## ISSUE SPECIFIC HEARINGS 4

### ERYC SUMMARY OF ORAL RESPONSES

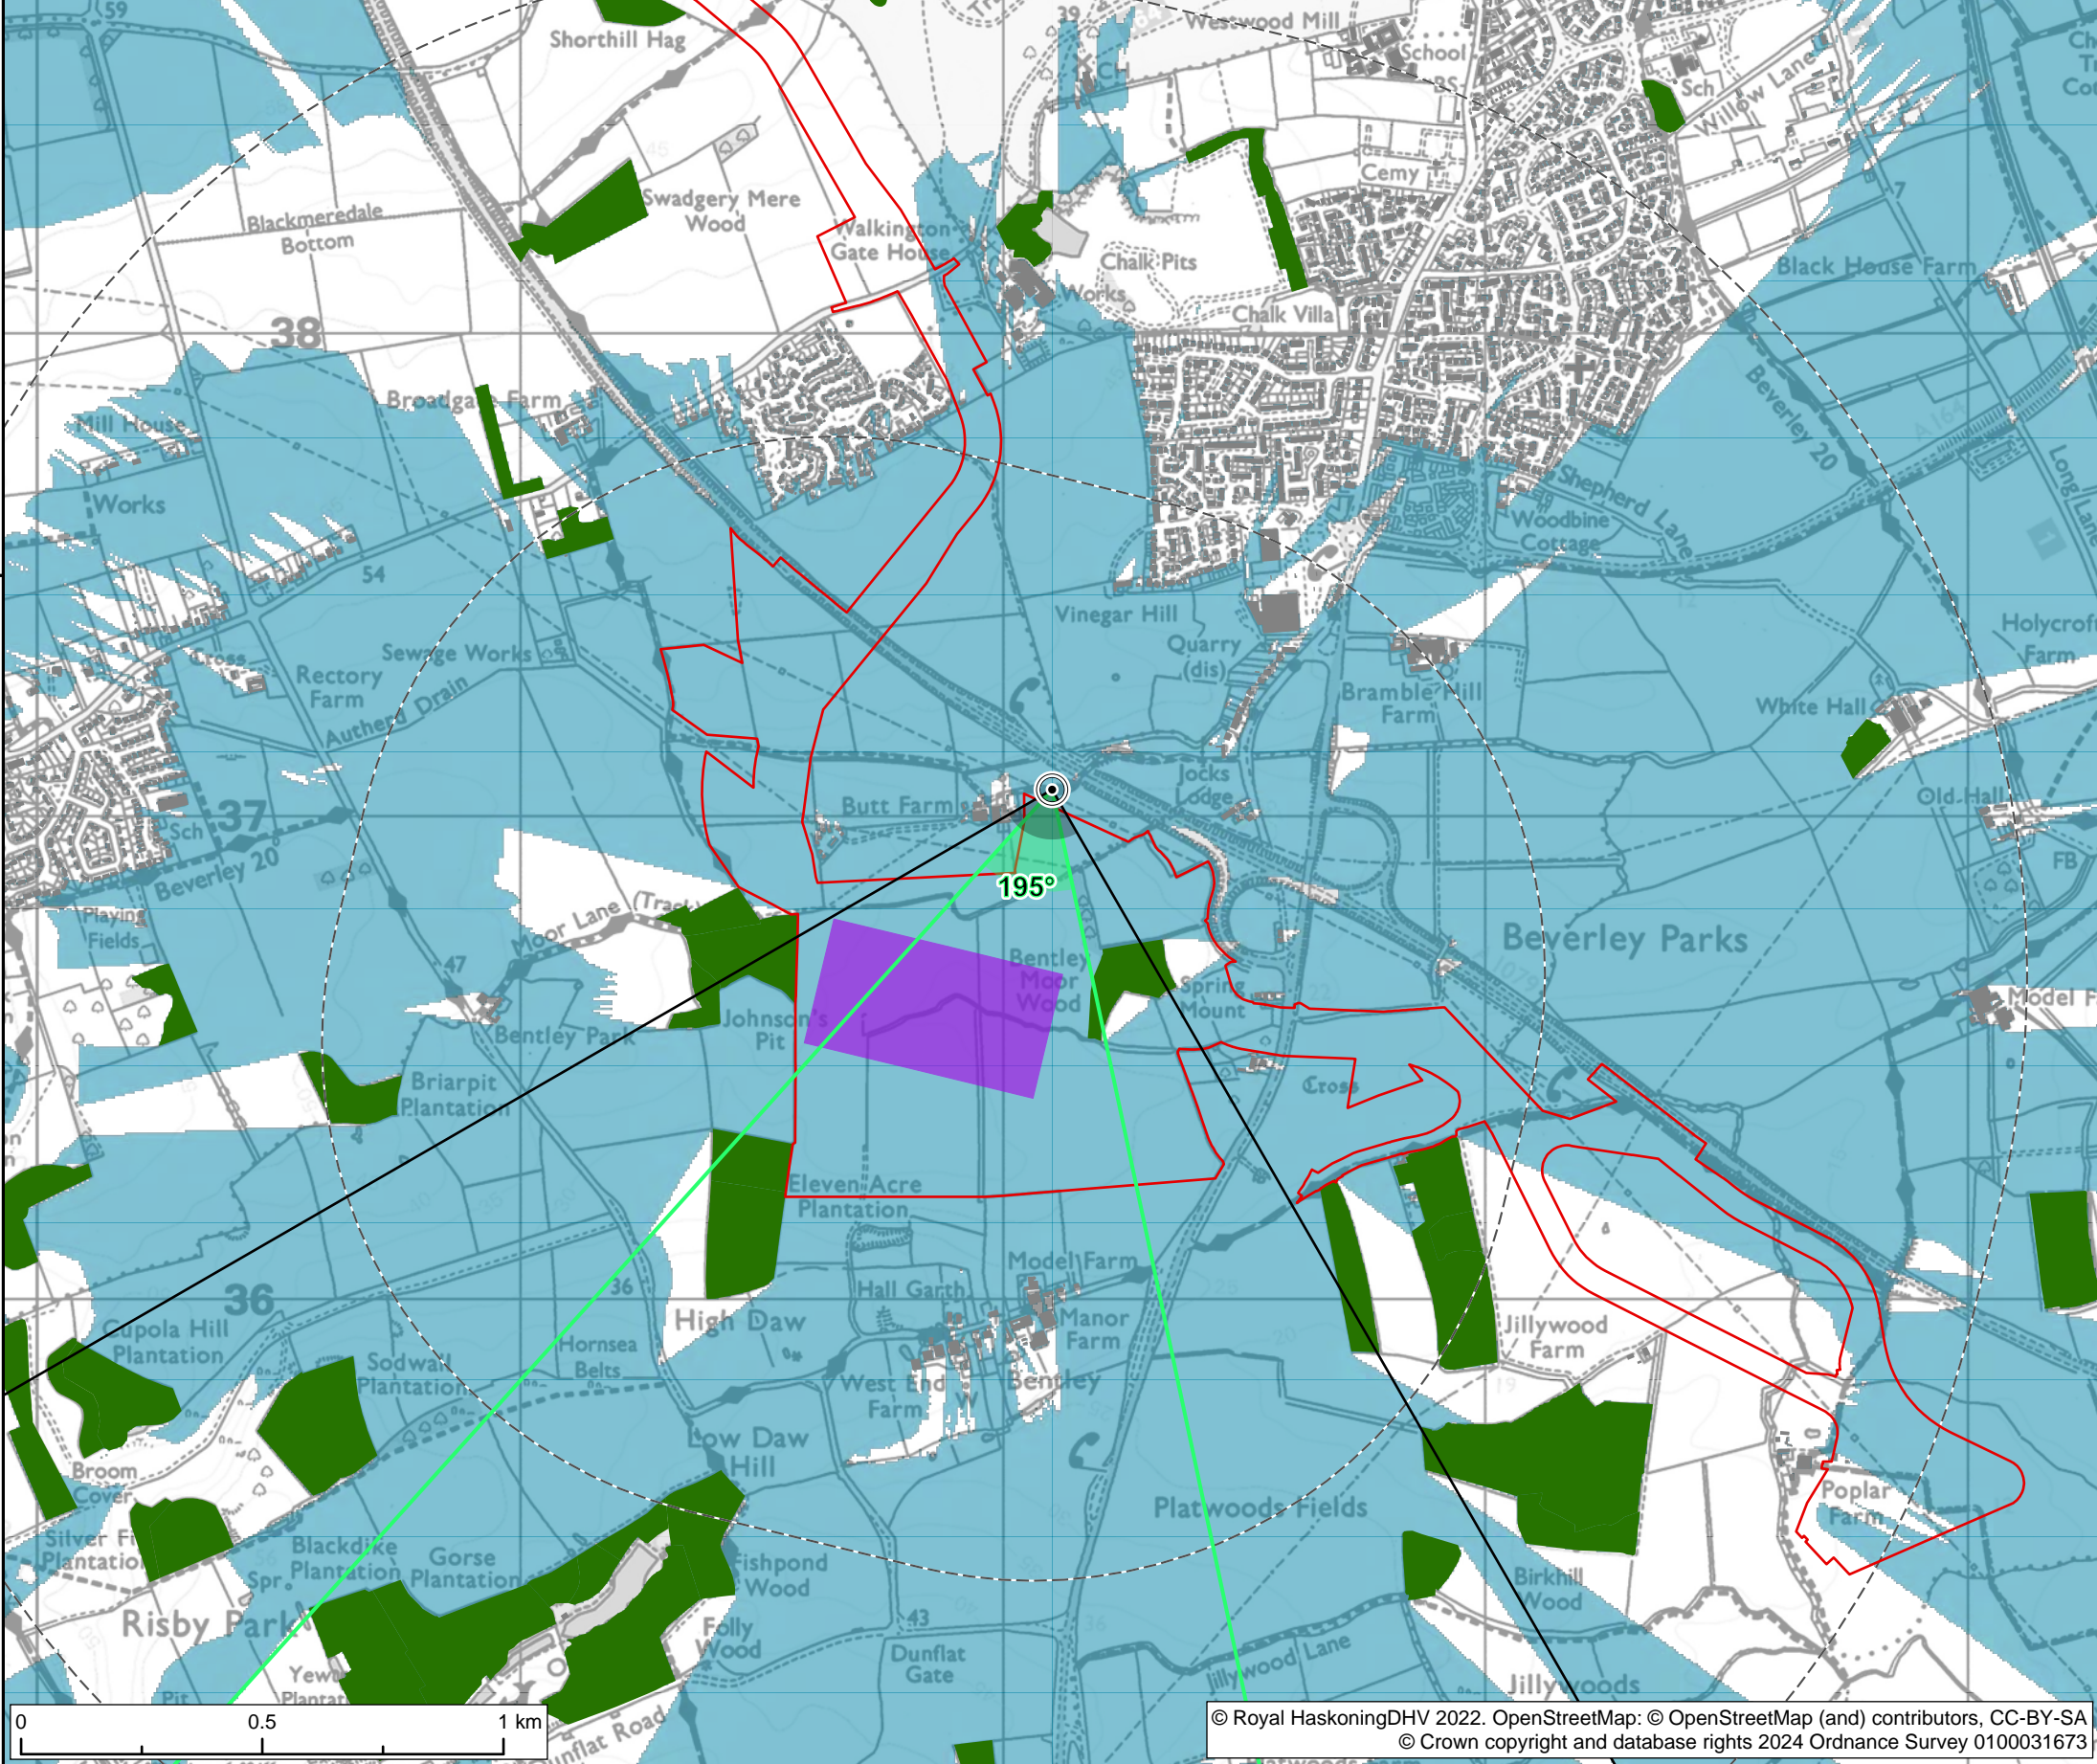
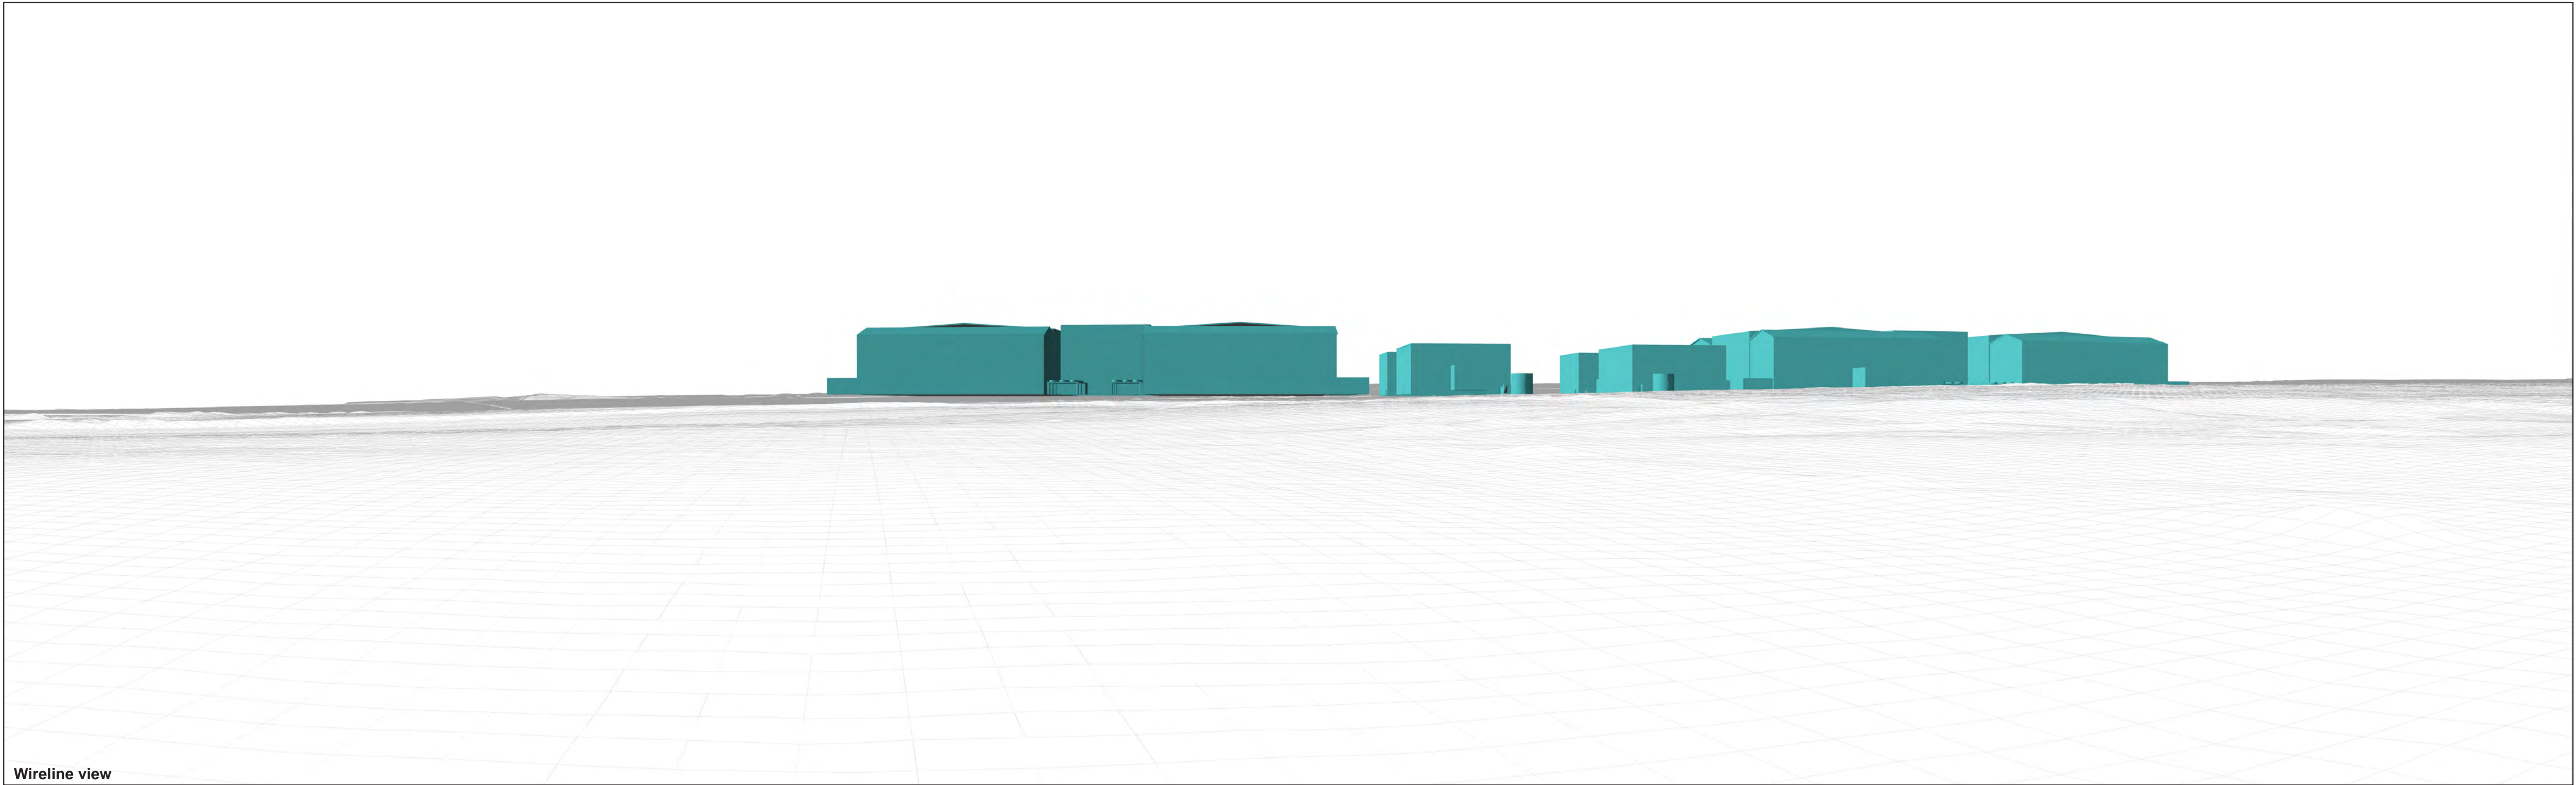
Agenda Item 3 Landscape character and visual amenity	
Question	ERYC Response
The ExA asked the applicants whether they felt viewpoint 1 represents an accurate visualisation of the likely effects from the most effected receptors, notably the residential and recreational uses of Butt Farm. Following the applicants comments ERYC views were requested.	Accept the applicants comments about normal practice being to select publicly accessible viewpoints and that this is the closest public viewpoint to Butt Farm. With regard to leaf cover this had also been raised in a recent meeting and it was noted that the plantation tapers towards the left of this view, which is the east of the view, and is considerably thicker towards the right, which is the west. Therefore in the area of the converter station we would have the greatest depth of mitigation planting. On that basis we accept that, even in a winter view, there would be quite effective mitigation planting for this view, which would thin out towards the left of the view. On that basis we would be content with the position that the applicant is taking on this view (BB)
